**BOTLEY WEST SOLAR FARM
OXFORDSHIRE HOST AUTHORITIES
RESPONSE TO
4 SEPTEMBER 2026 CONSULTATION
DEADLINE: 4 OCTOBER 2026**

Botley West Solar Farm (EN01014)

OXFORDSHIRE HOST AUTHORITIES RESPONSES TO CONSULTATION 1 DOCUMENTS

Comments on applicant's documentation submitted in response to the information request of 14 April 2026 (re-issued 20 and 28 April 2026)

\*\*\*\* New Public Access including: Cycle Path and Permissive Path

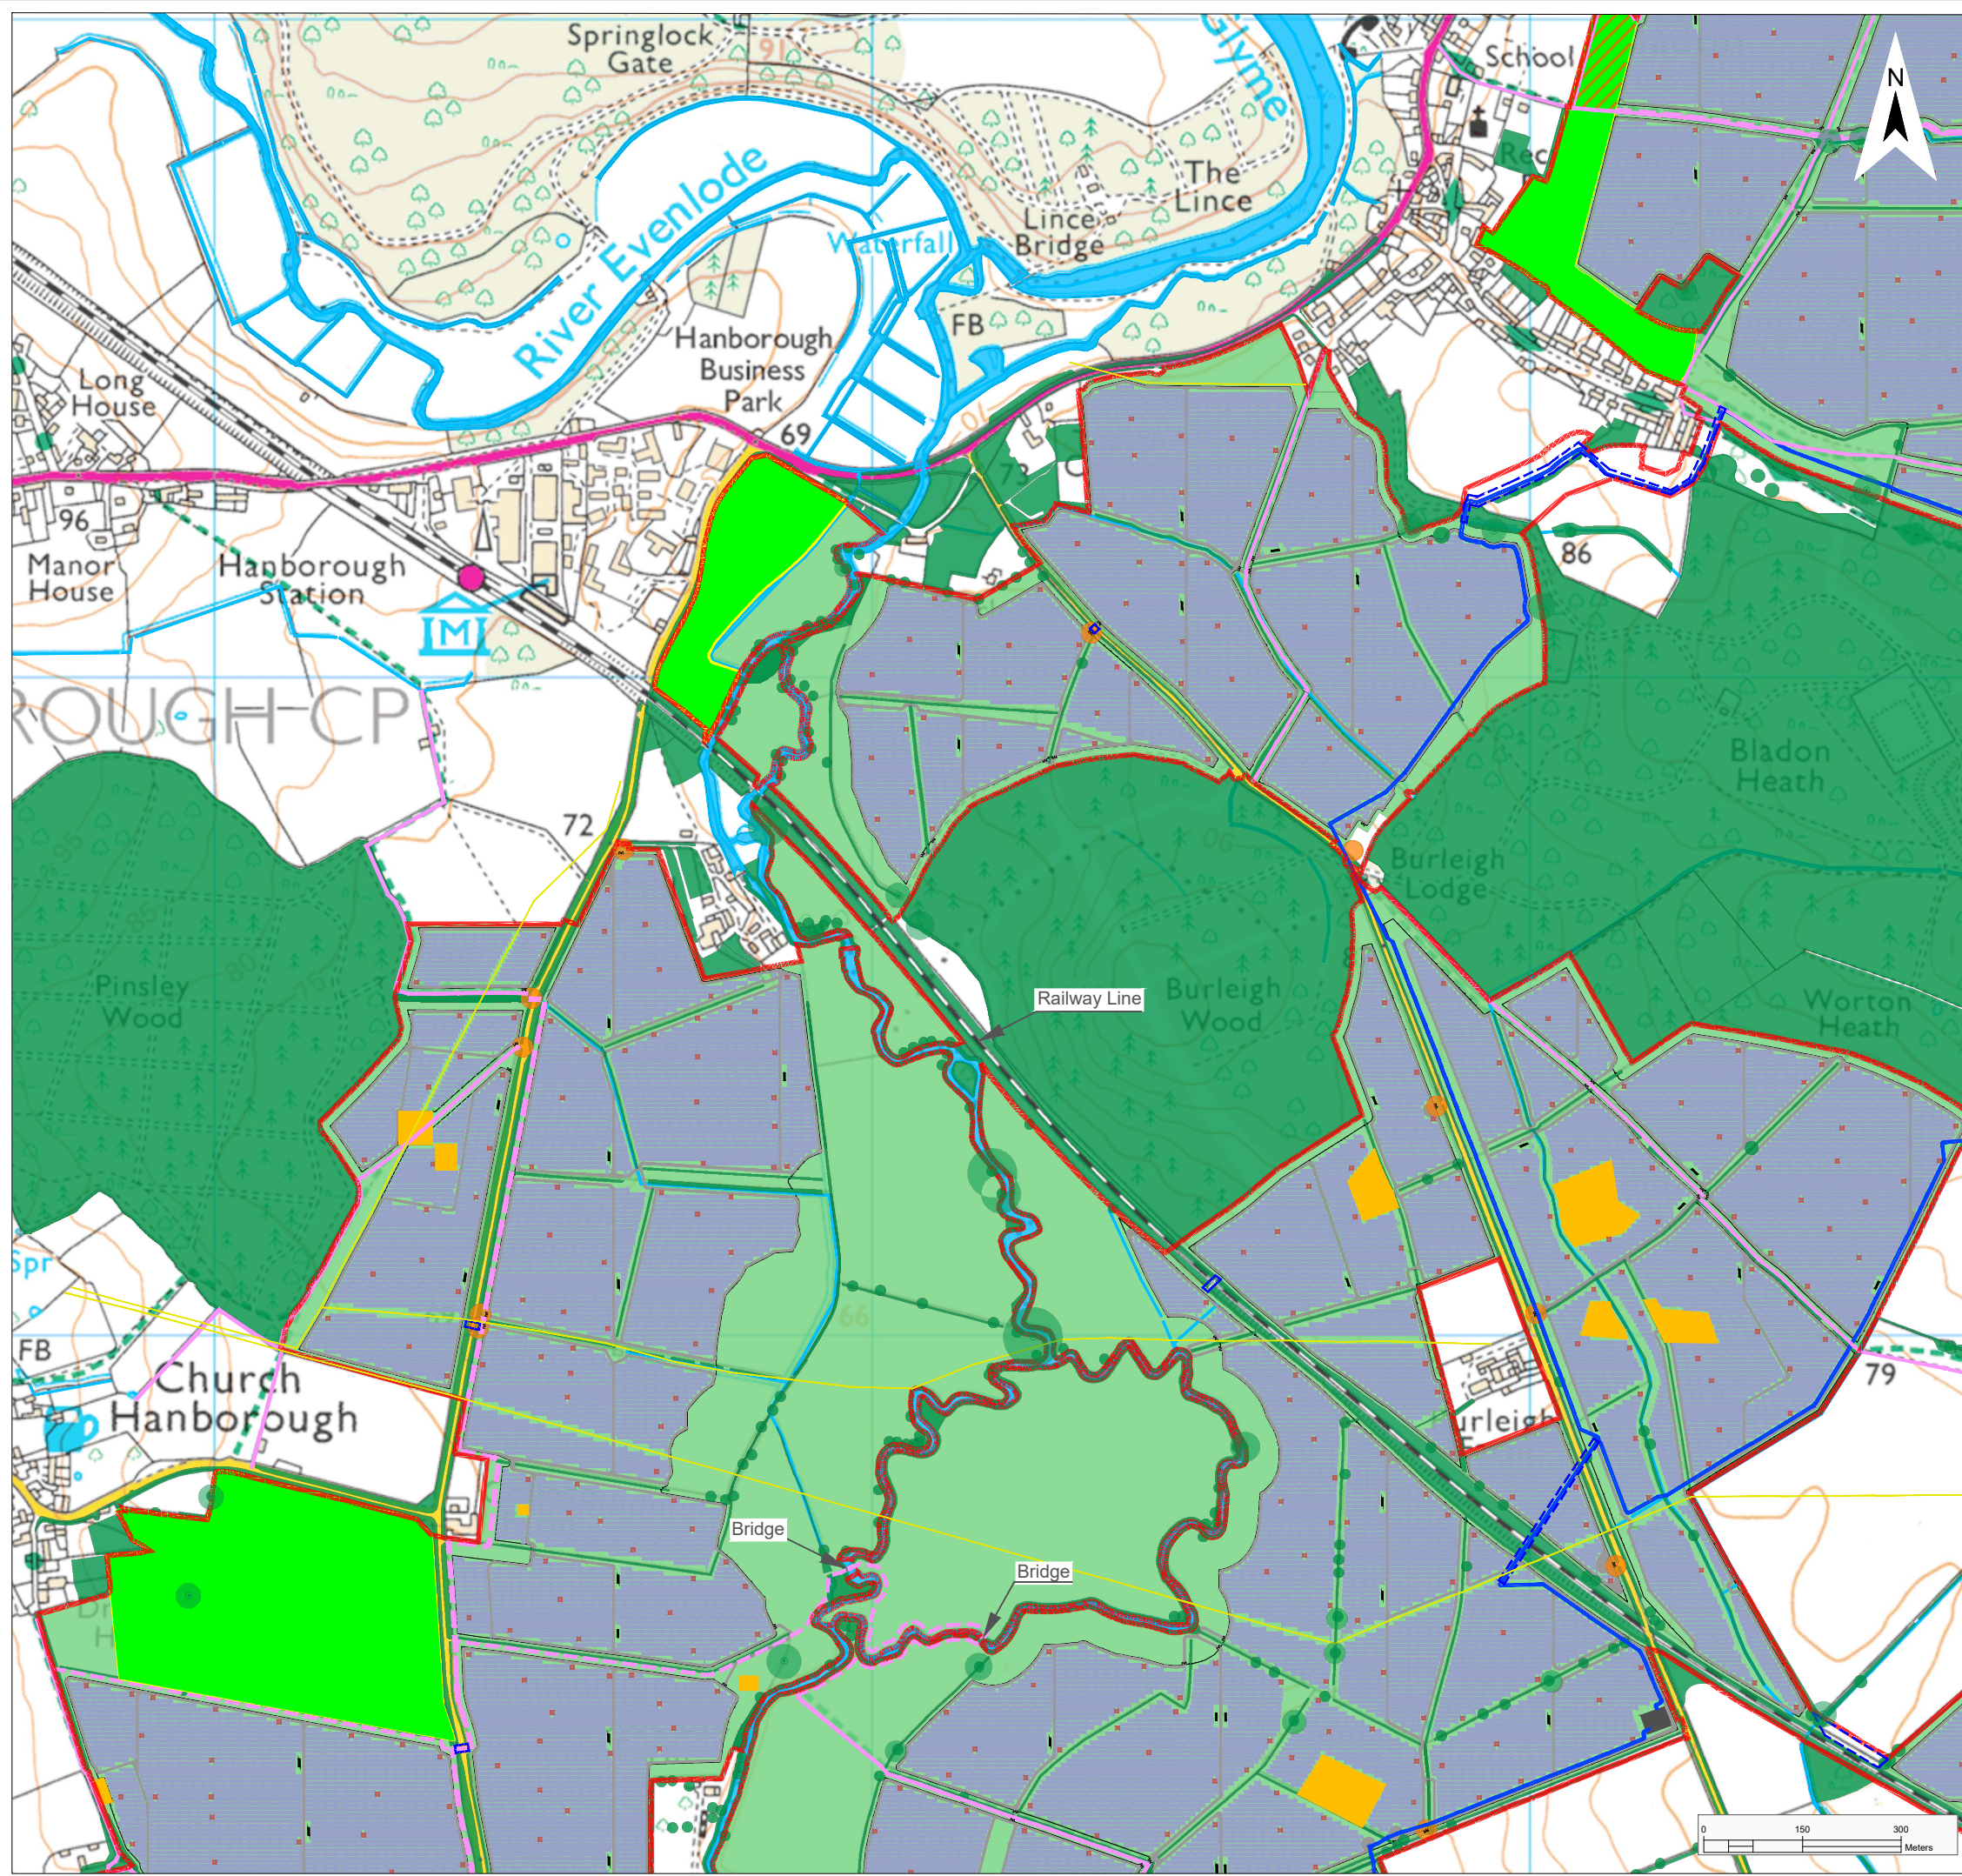
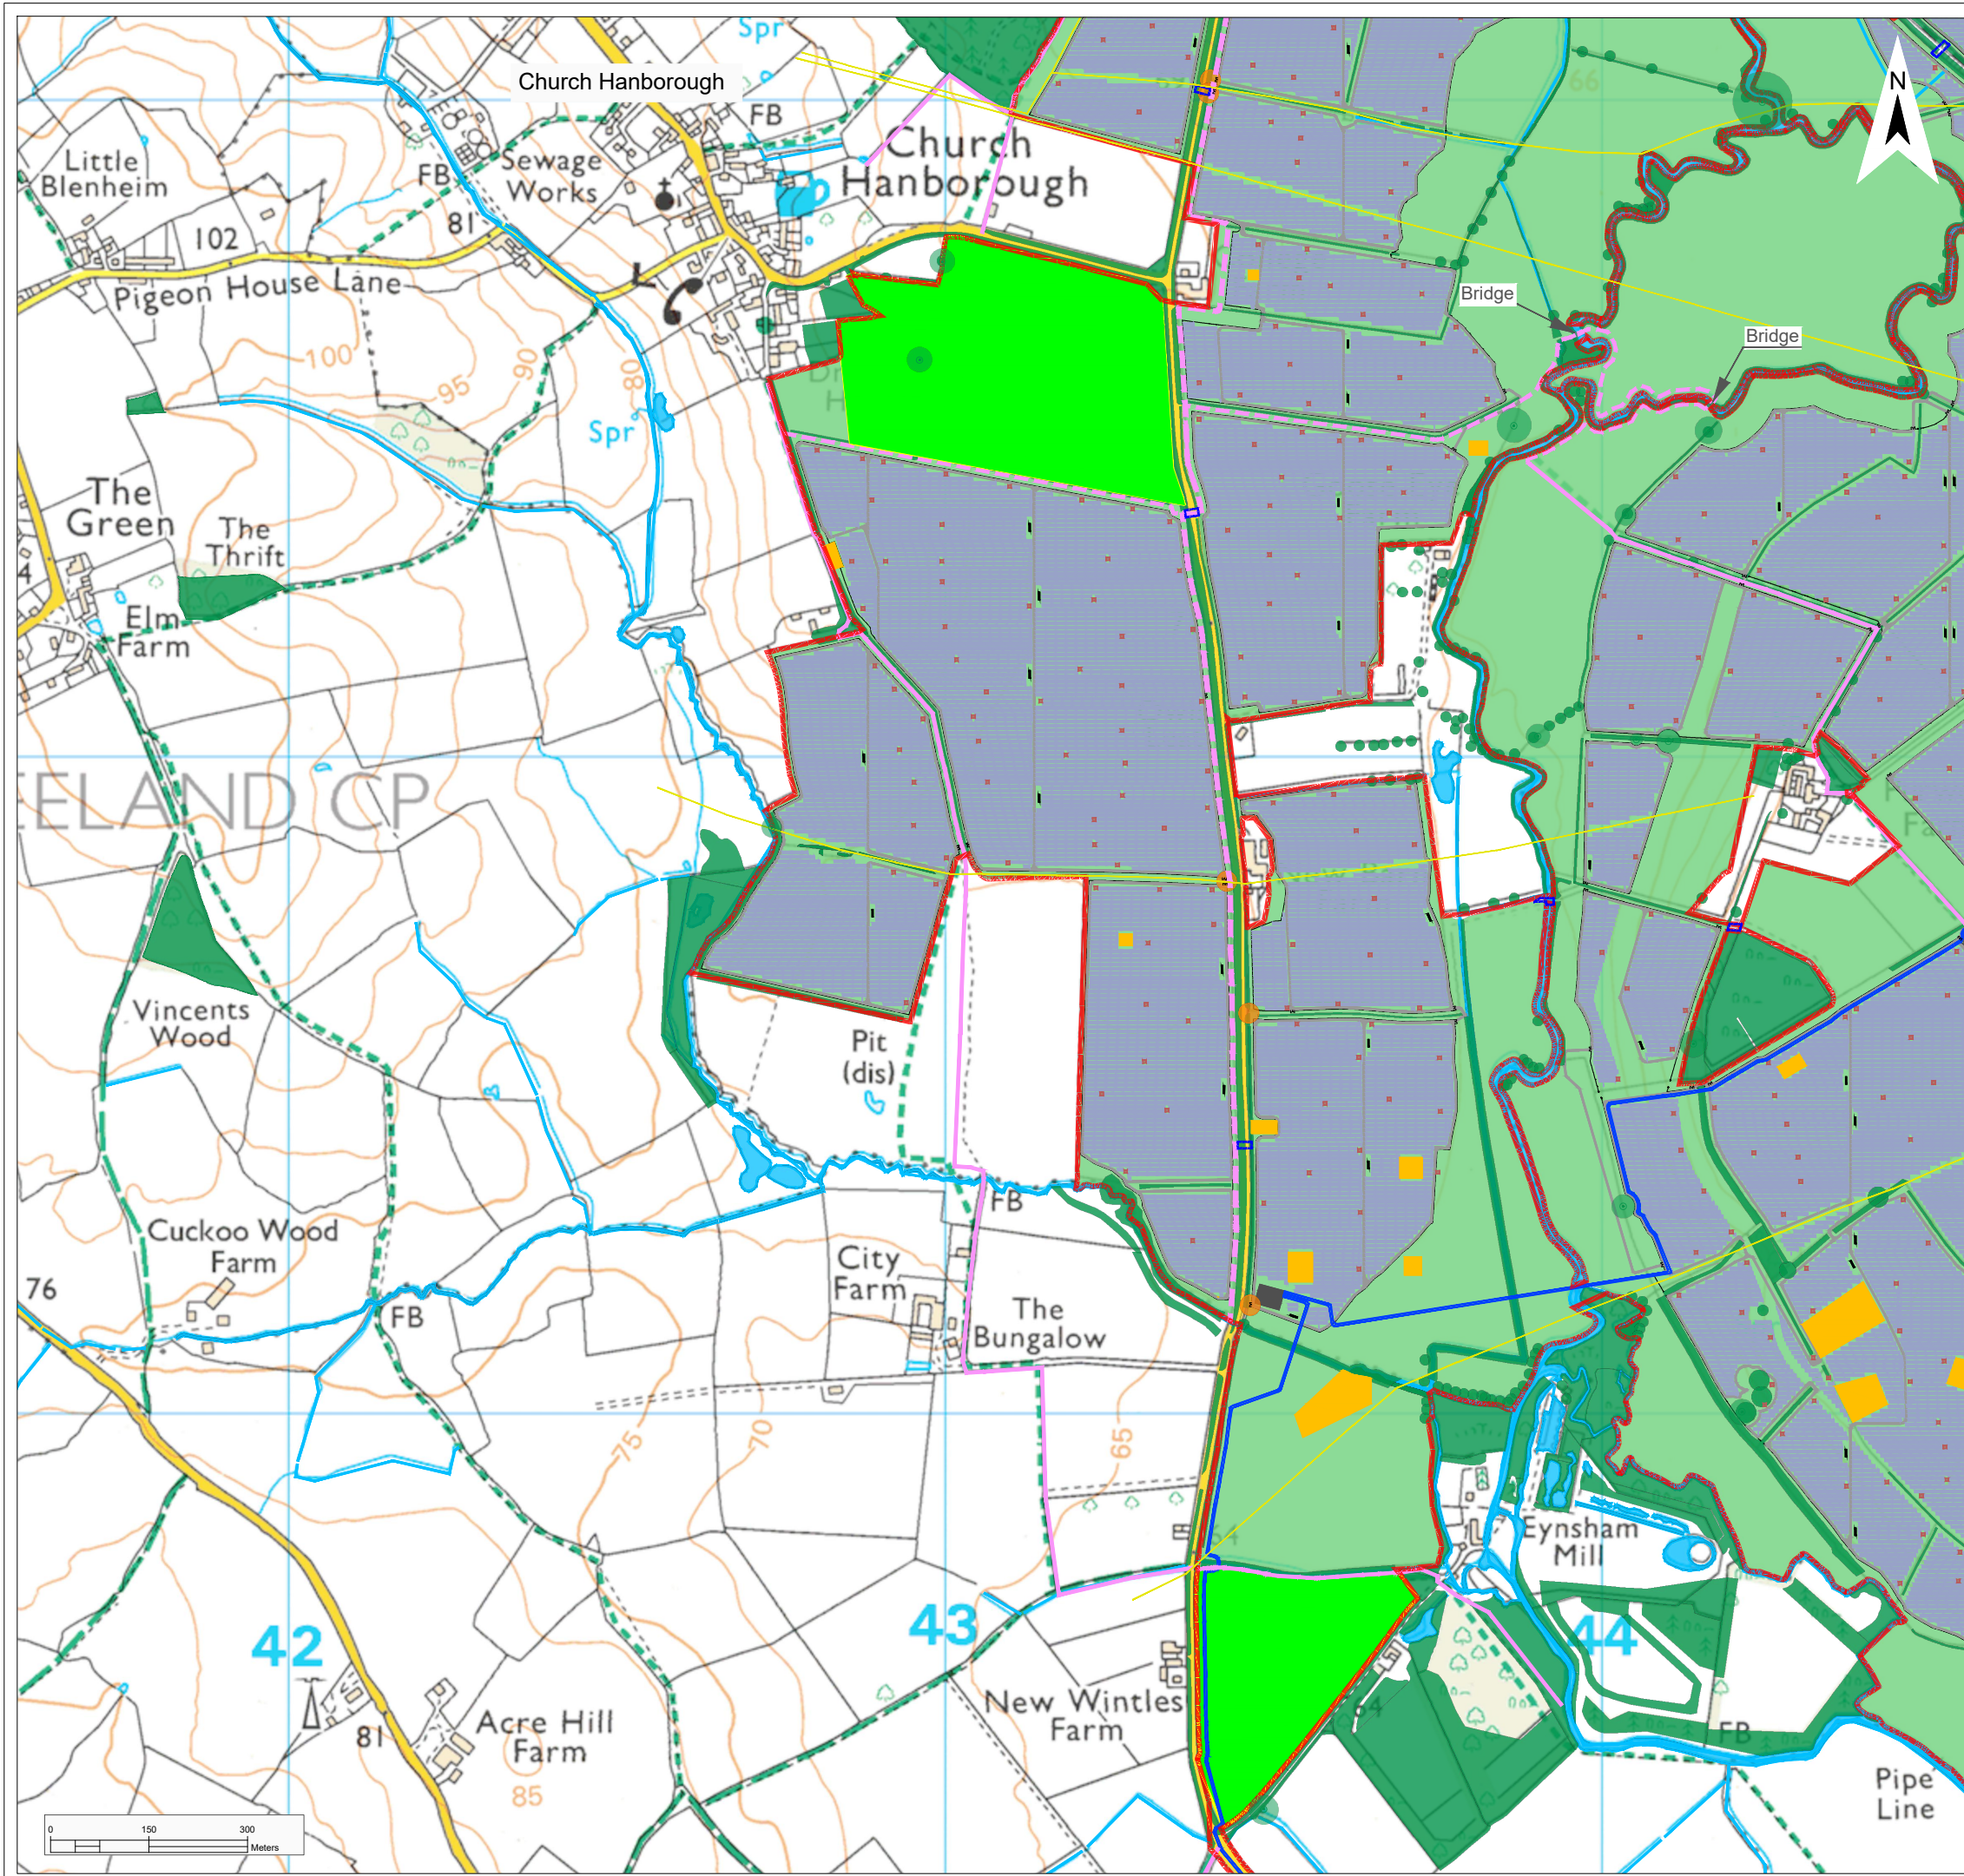
The OHA wishes to draw the Secretary of State's attention to previous comments OHA provide in their response [REP6-118] for panel removal on a field-by-field basis. Whilst Rev 5 is a betterment on the Rev 4 plan, the changes in the OHA's view do not go far enough in delivering a scheme that minimises landscape and visual impacts to a more acceptable level.
